Director of Development Services
Ribble Valley Borough Council
Council Offices
Church Walk
Clitheroe BB7 2RA

Drafted 22 November 2011

**Planning Application, Ribble Valley District
D3-11-0796 Sunnymeade Cottage, Hawthorne Place, Clitheroe**

Project Proposed Dwelling in Grounds of Sunnymede Cottage, Hawthorn Place, Clitheroe For Mr. A. Field.			Ron Valovin, Architectural Services, 9 Green Drive, Clitheroe, Lancs. BB7 2BB. Tel. 01200 427167.	
Title SITE PLAN.				
Scale 1-200	Date 27/7/11	Drawn RUV	File Name	379-2

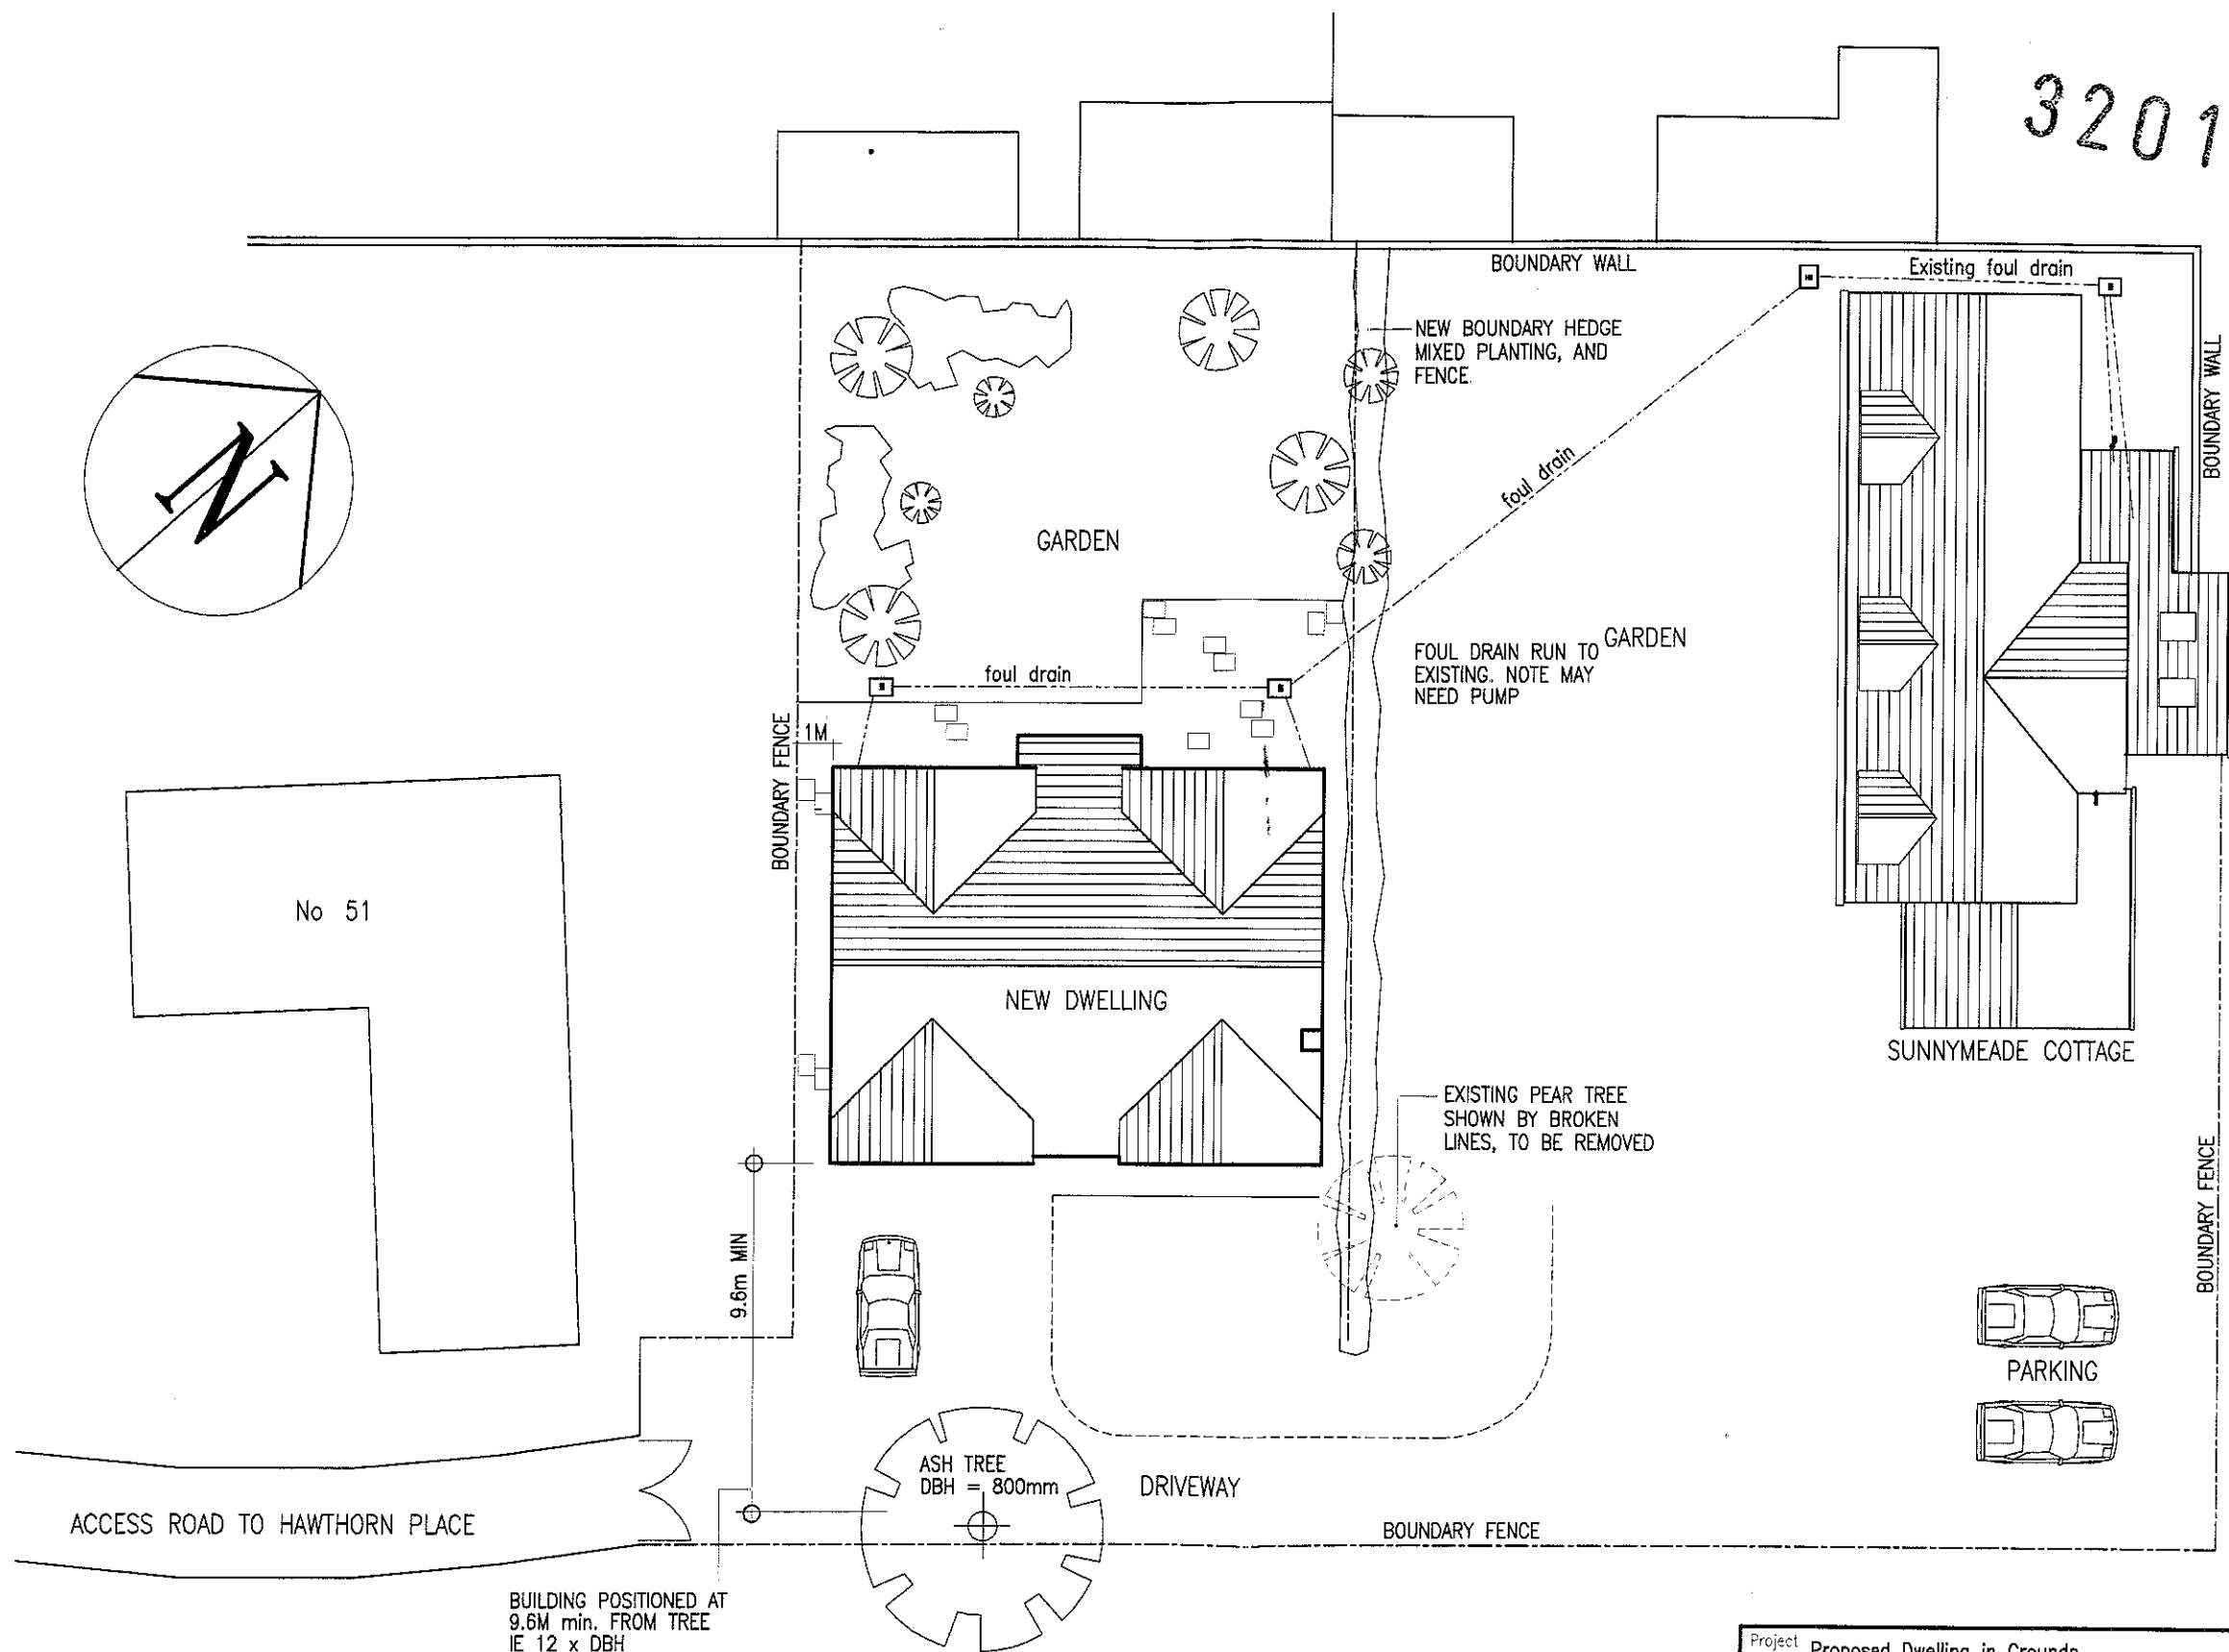
The development will introduce some additional vehicular activity along Hawthorne Place, but will have a marginal impact on the general level of activity in this immediate area.

The provision of four off street parking spaces is consistent with LCC parking requirements for a property of this type.
